Our Ref: EN010147

Application by Photovolt Development Partners (PVDP) on behalf of SolarFive Ltd for an Order Granting Development Consent for the Botley West Solar Farm

Advice following issue of decision to accept the application for examination

Project		Status			
Botley West Solar Farm		Illustrative			
Id.	Changes	Date	Name	Date	Name
				01.11.2024	V. Guskova
				01.11.2024	H. Trabelsi
				Drawing No	EN010147/APP/7.3.2
A	Created	01.11.2024	VG		
Scale:		1:65000		at A3	
Title					
Operational Development Plan

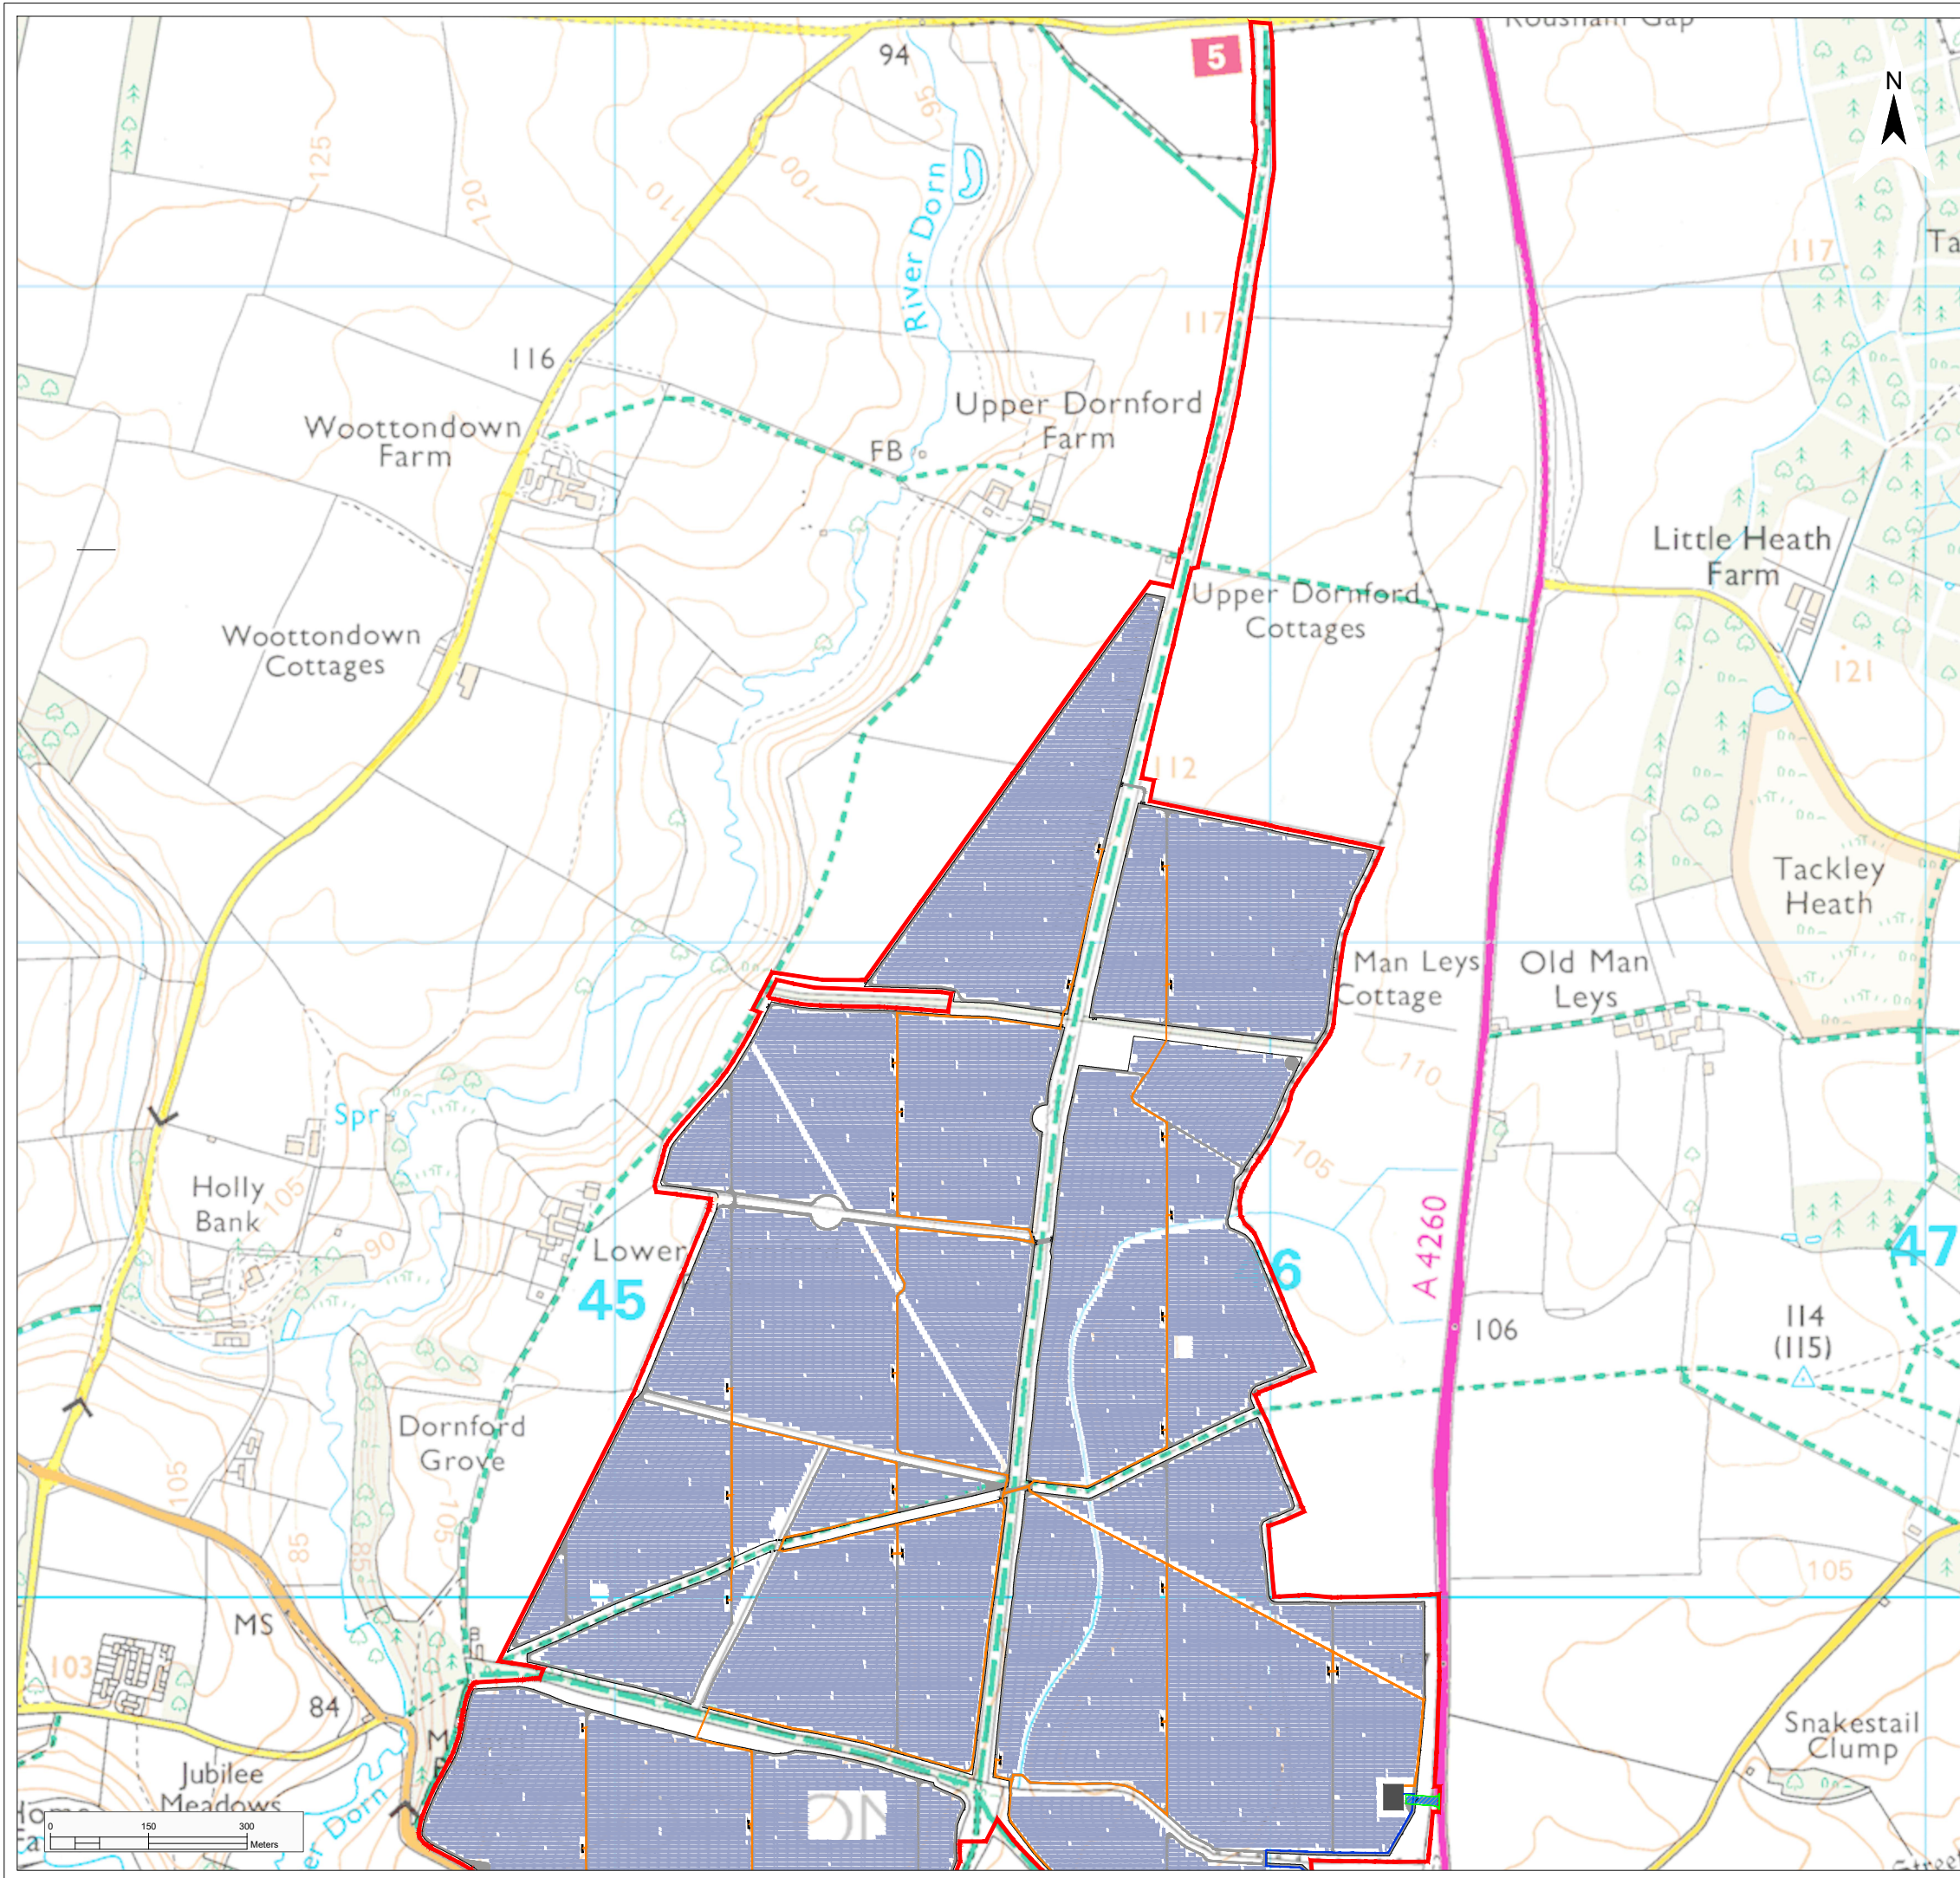
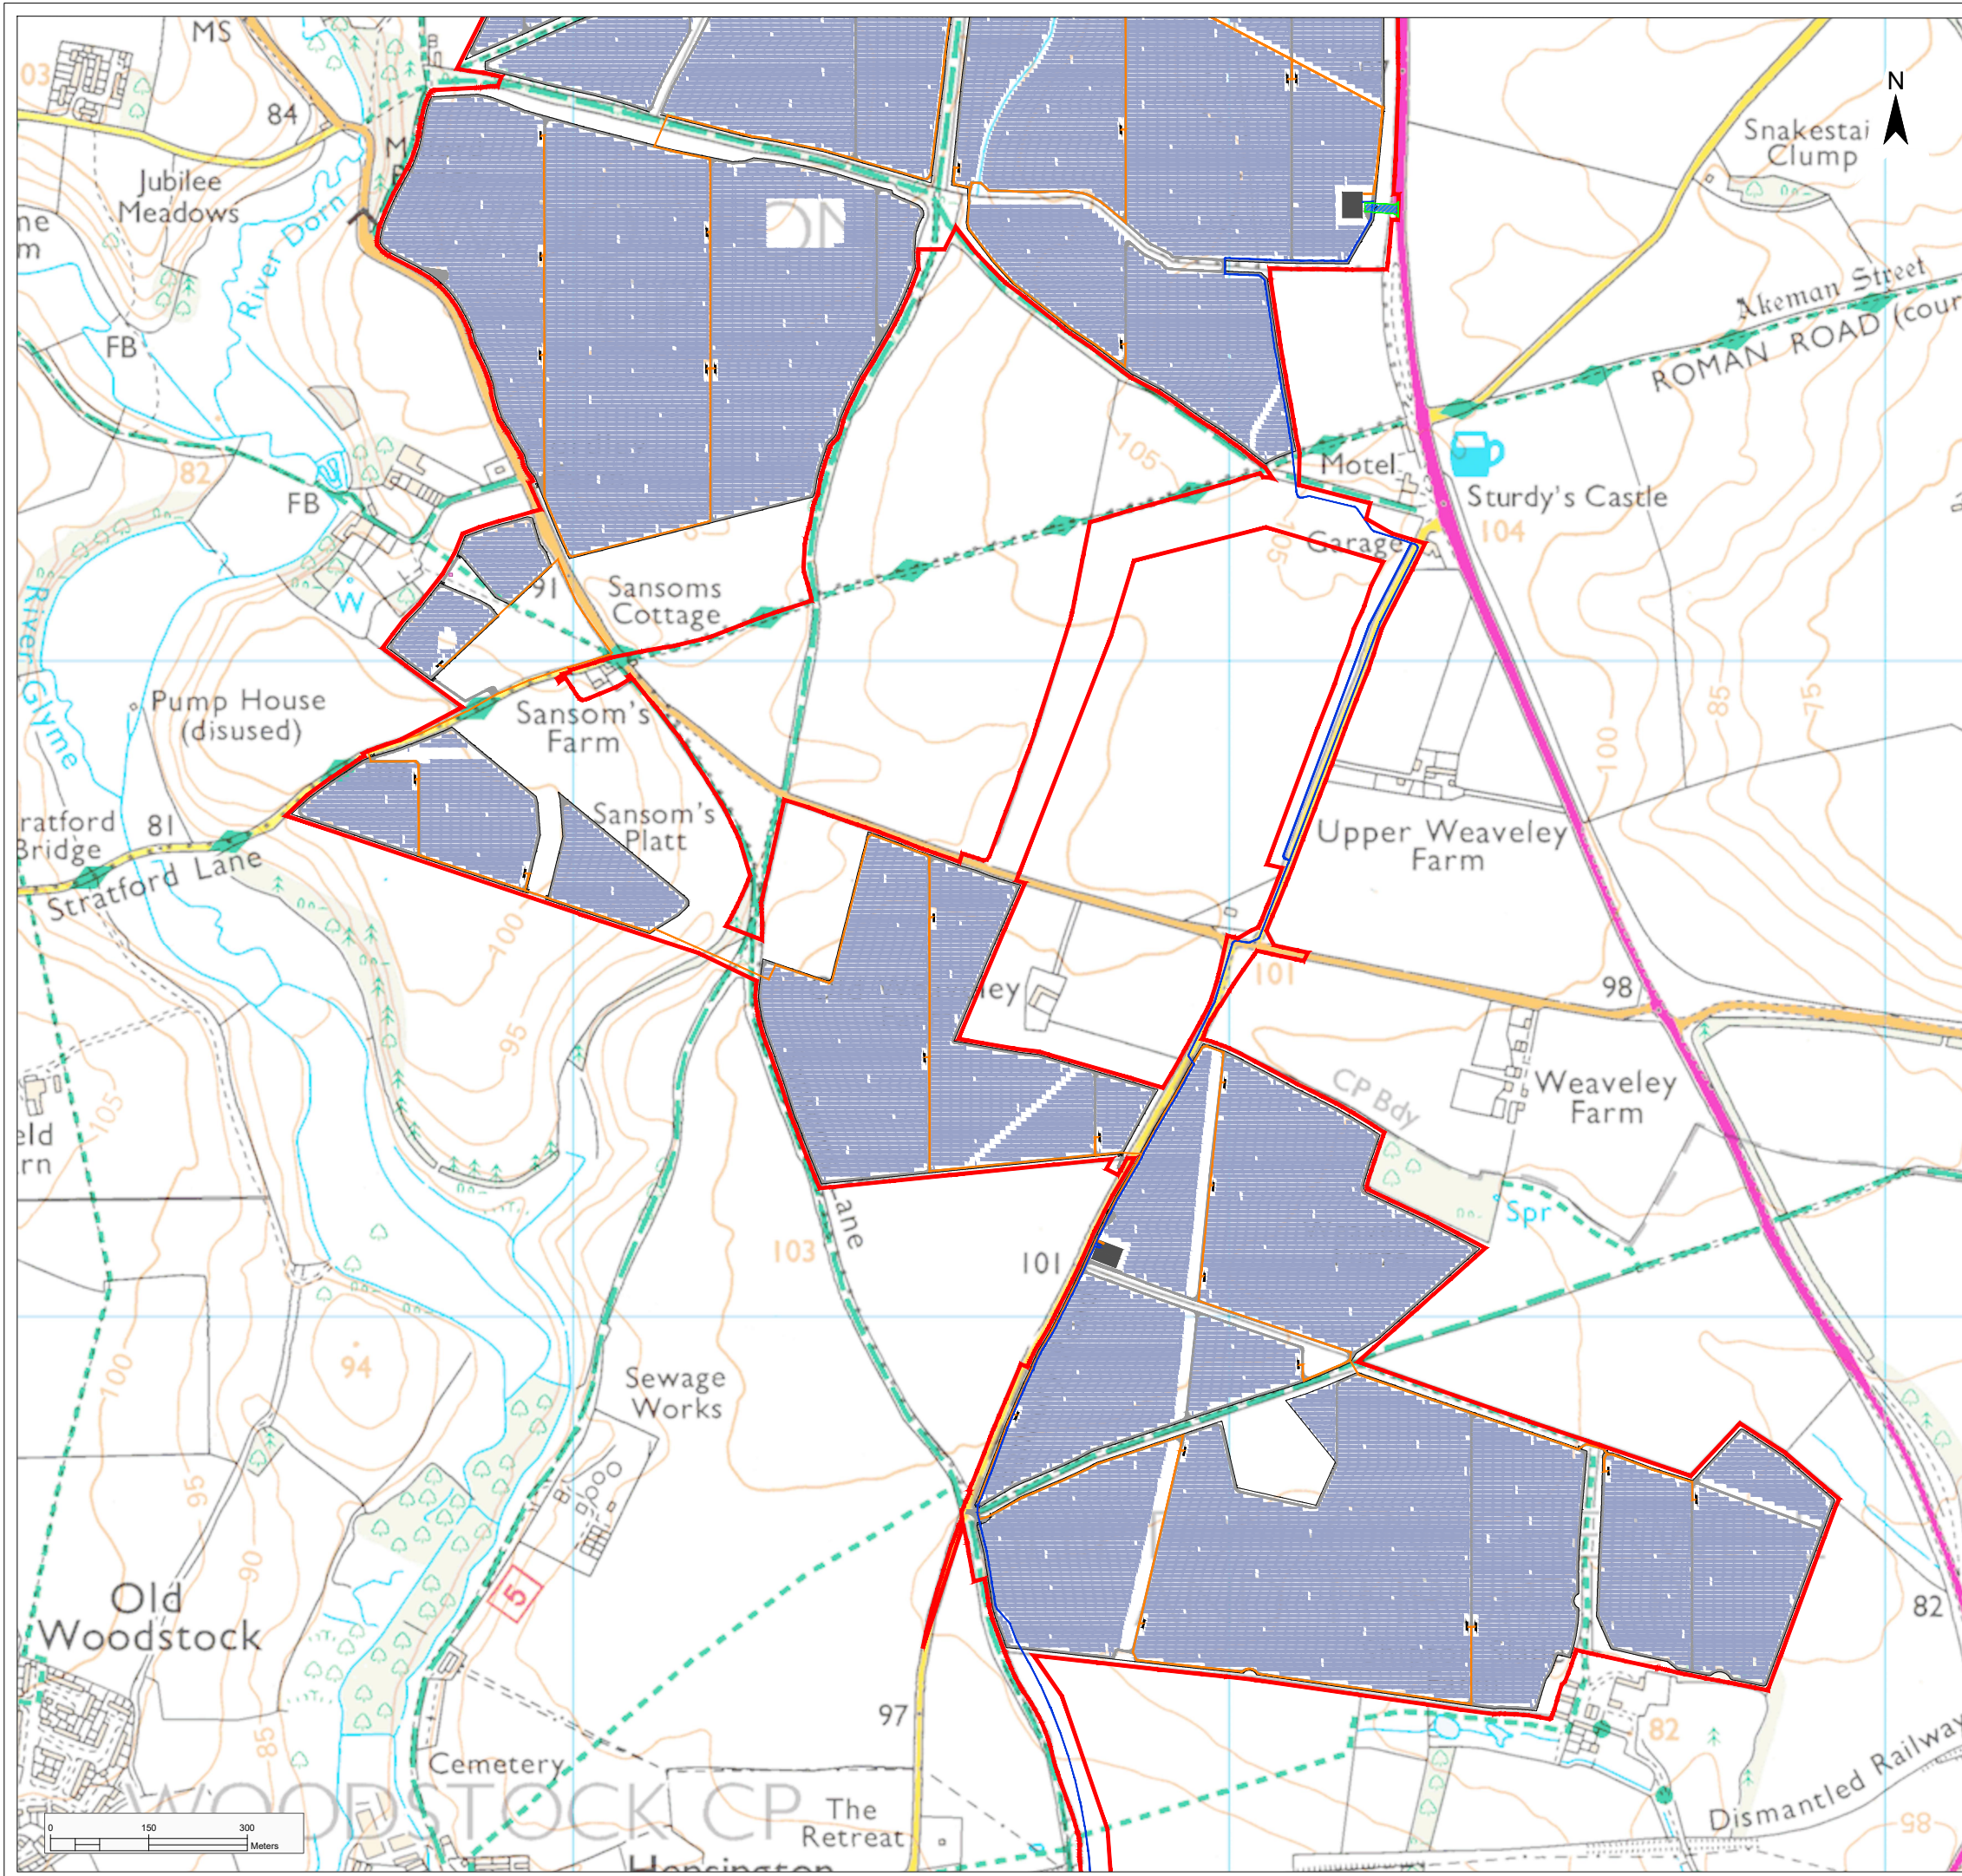
Operational Development Areas Plans (Doc 7.3.2), Landscape, Ecology & Amenities Layer Plan (Doc 7.3.3) and Temporary Facilities Plans (Doc 7.3.4)

The Inspectorate draws the attention of the applicant to APFP Regulation 5 (4A) in relation to these plan documents. The applicant may wish to amend these plans to ensure that the scale being used follows this regulation. For the benefit of the understanding of all parties to a future examination it may be desirable if it was more clearly presented on the plans which areas are within the Order Limits and how the sheet in question fits in the context of the wider site.
